MODIFICATION REQUEST:

Blocks 6 and 7, Central Park

MP 11_0091 MOD 1

**Modification to internal and external components
of the approved commercial and retail
development**

Approved Section 75W Modification Application

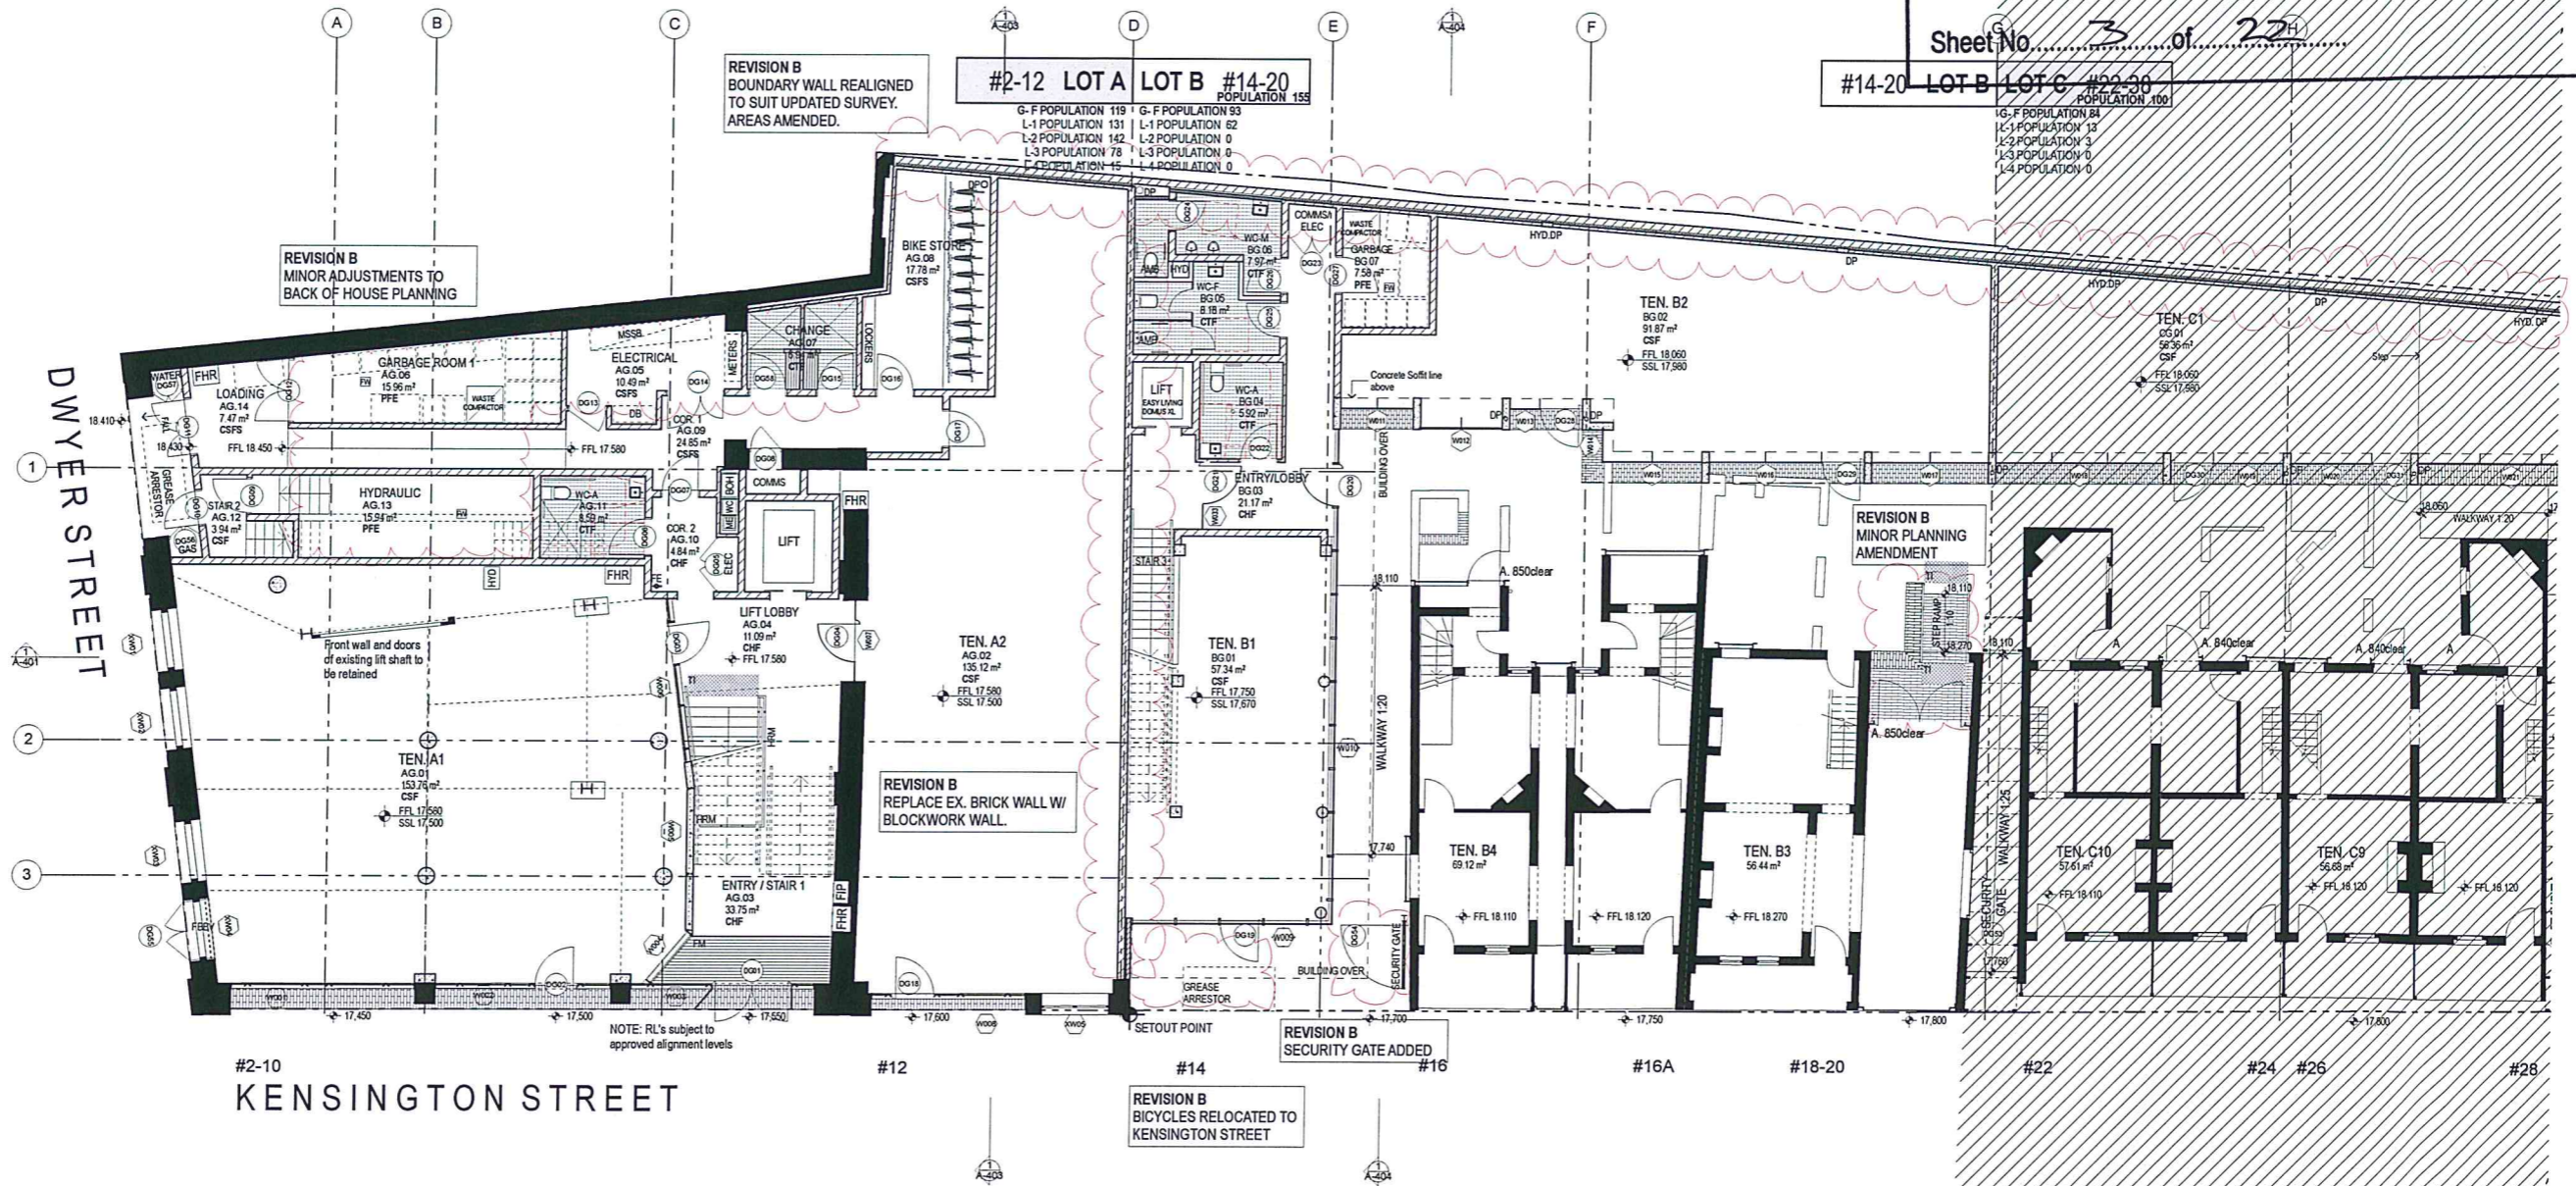
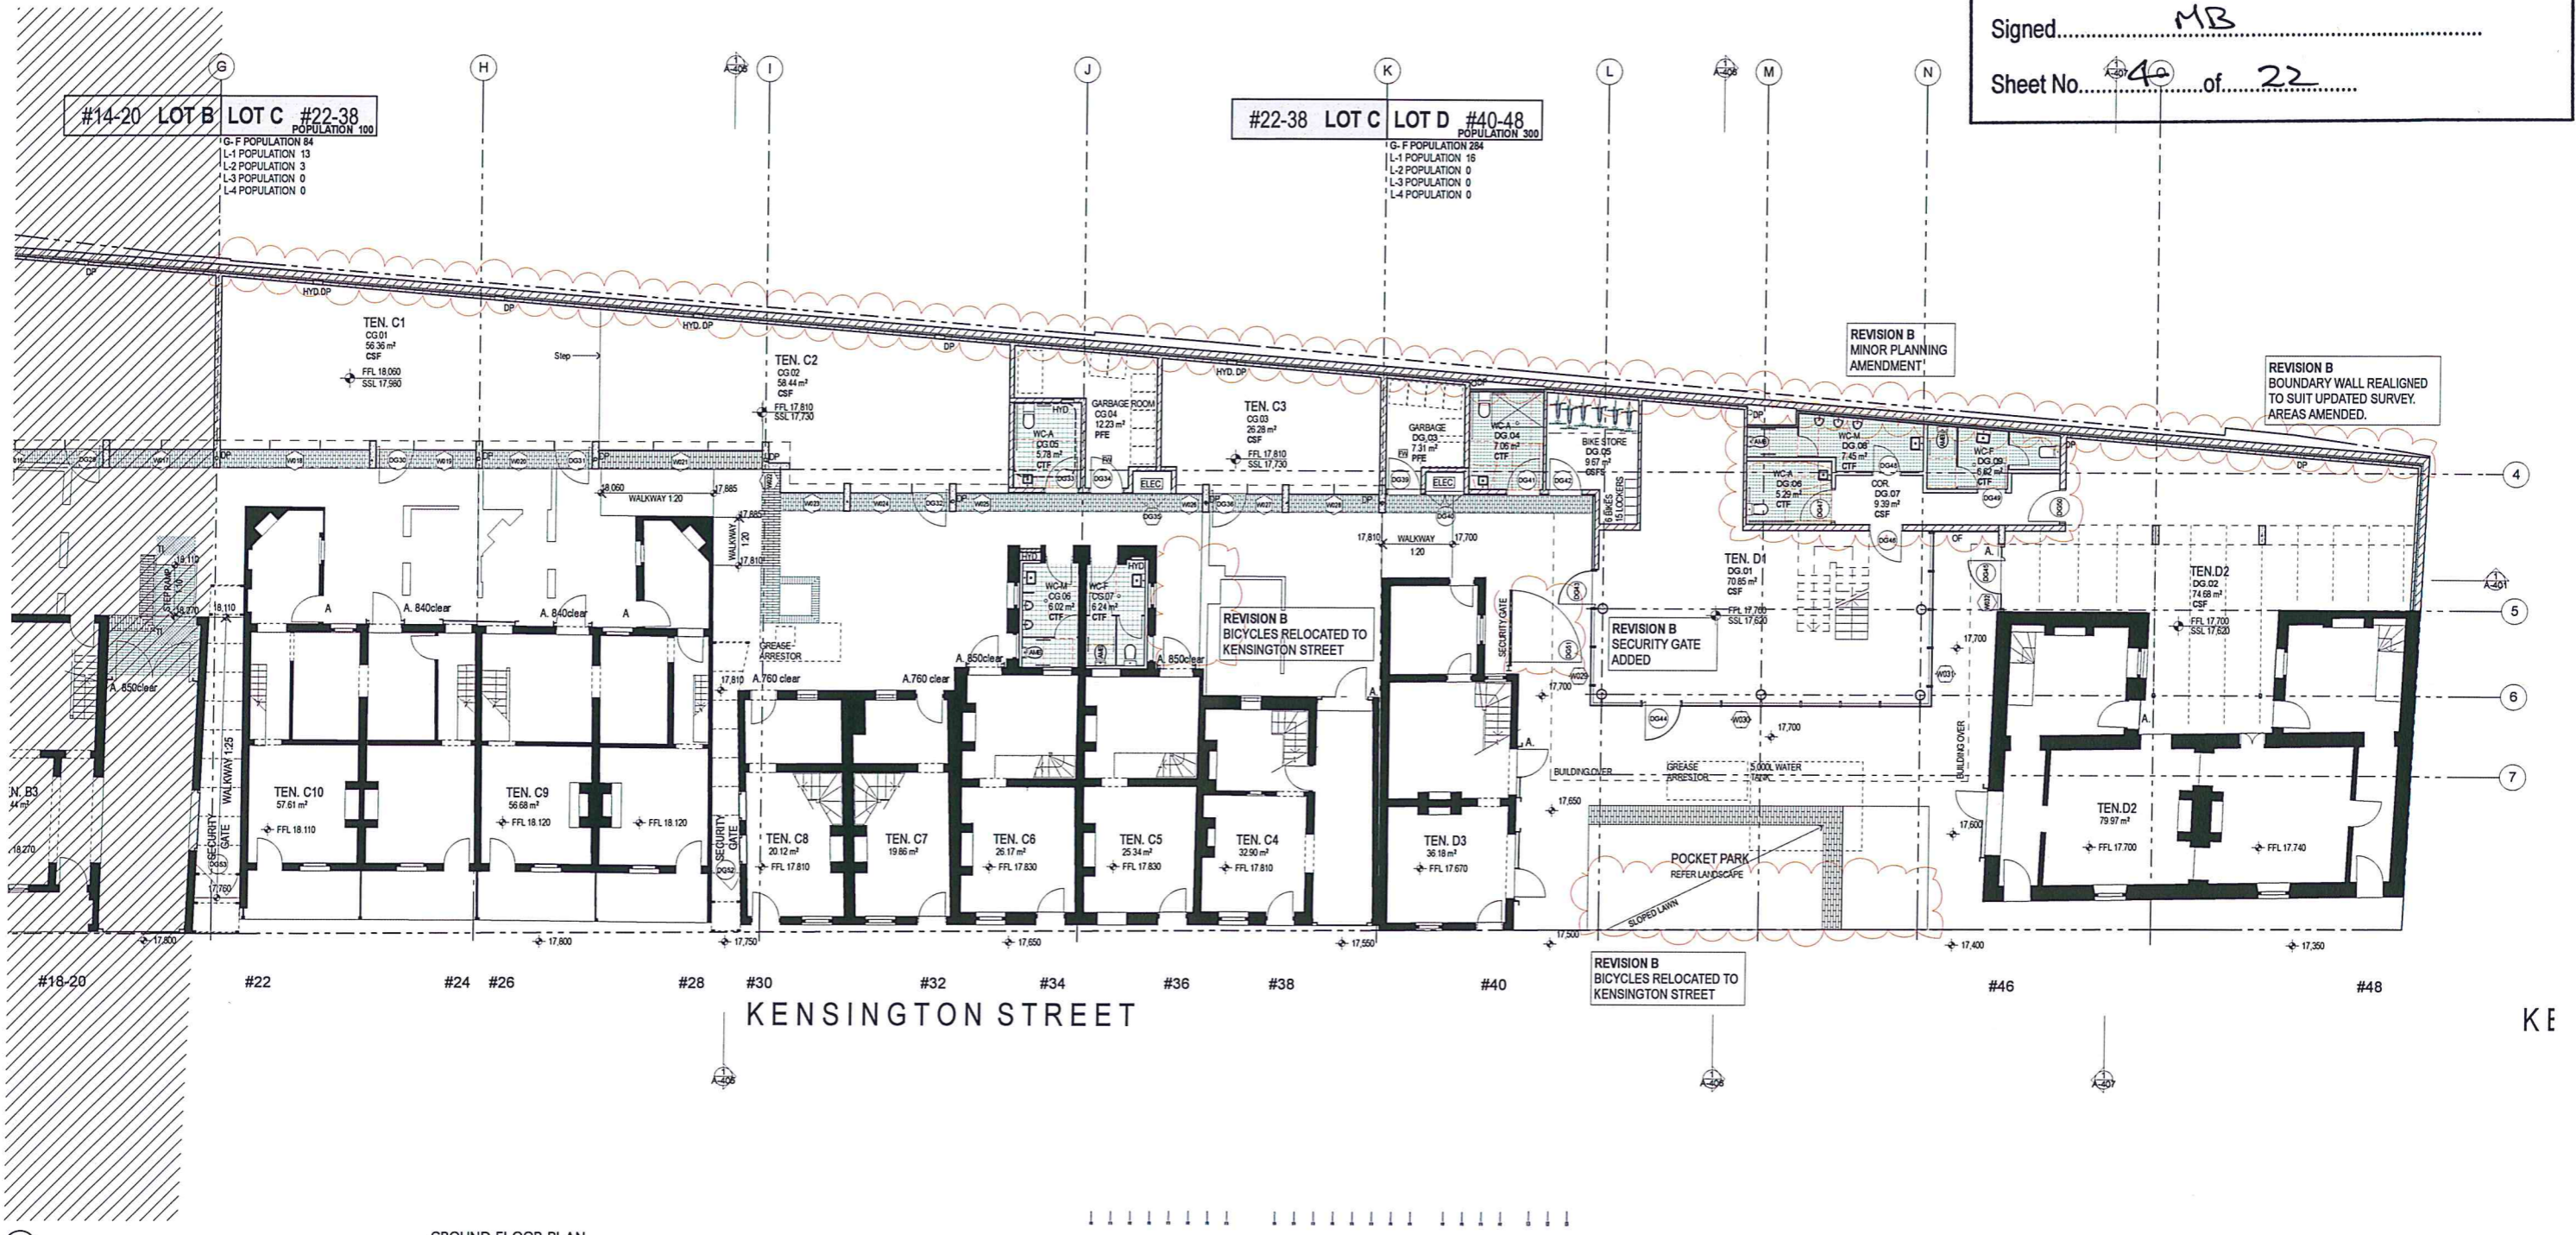
The proponent seeks to undertake minor internal modifications to the approved development, as illustrated in **Figure 2** and **3**. These predominantly include modifications to bathroom facilities and plant rooms, which are proposed to improve the efficiency and access throughout the buildings and into the rear laneways. The department supports these minor modifications that provide greater access to these areas.

Another proposed amendment is the replacement of the existing dividing wall between No. 12 and 14 (ground and first floor), which was originally proposed to be retained. The existing wall has been found to be unstable and unsuitable for retention. The proponent's heritage consultant advised that the replacement of this internal wall will not have any negative impacts upon the heritage significance of the site. It is noted that Council also did not raise any concerns with this modification on heritage grounds. The department therefore supports this internal modification.

KEY - WEST ELEVATION

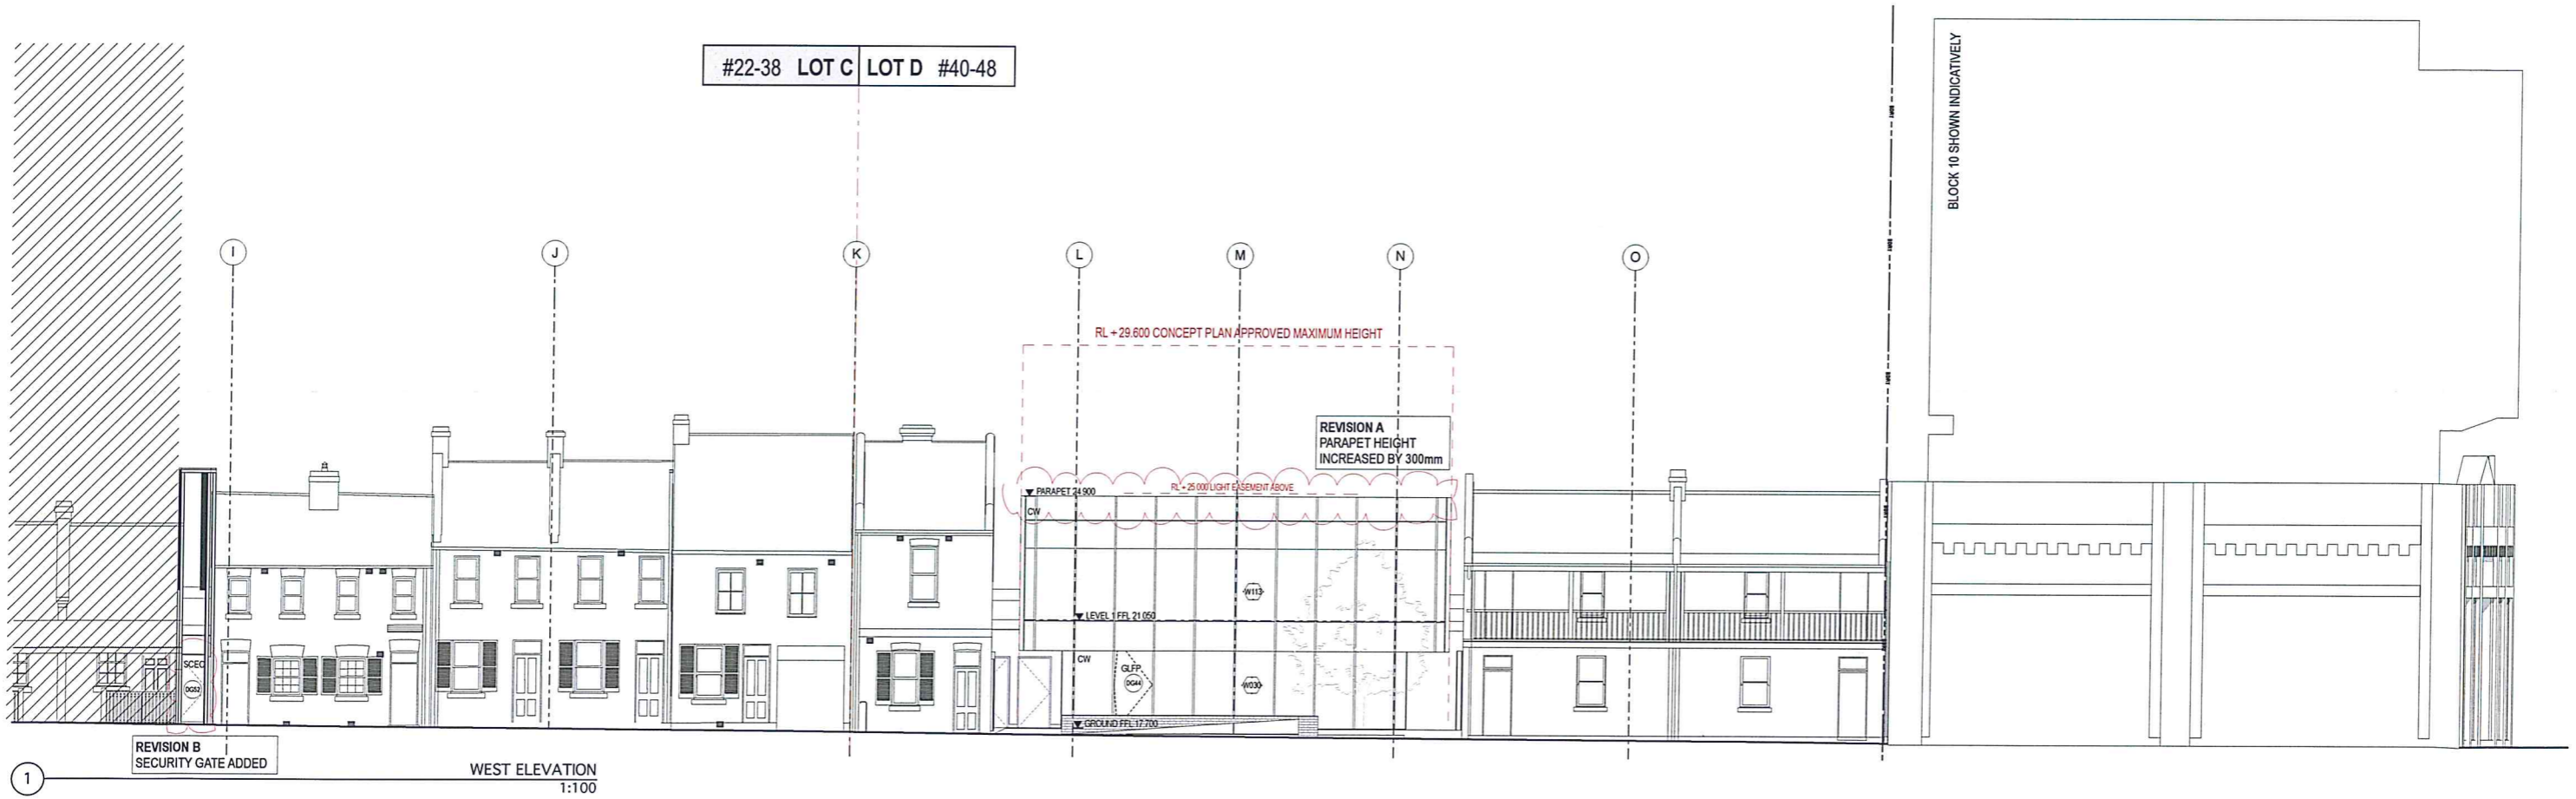
- the proposed internal and external modifications are generally supported;
- no concerns are raised with the deletion of condition B4 and B6(b); and
- concerns are raised with the proposal to reduce the height of the glazing on the western façade of the rear laneway buildings to 2.7 metres (this glazing was previously provided at varying heights across this facade) on the basis that the modification does not contribute to design quality of the buildings.

The approved glazing height on the western façade of the rear laneway building is to be reduced to 2.7 metres (this was previously provided at varying heights across this façade). A comparison between the approved and proposed elevation is provided at **Figure 7**. In support of the modification, the application was accompanied by a Heritage report which notes that there would be no heritage impact from this modification.

The proposed reduction in height of the glazing is considered to be an improvement over the extensive use of glazing compared that originally approved and is supported.

Council has since reviewed the additional information and has confirmed that the design quality of the proposed modification to the glazing height is acceptable and on this basis, it raises no objections to the amended application.
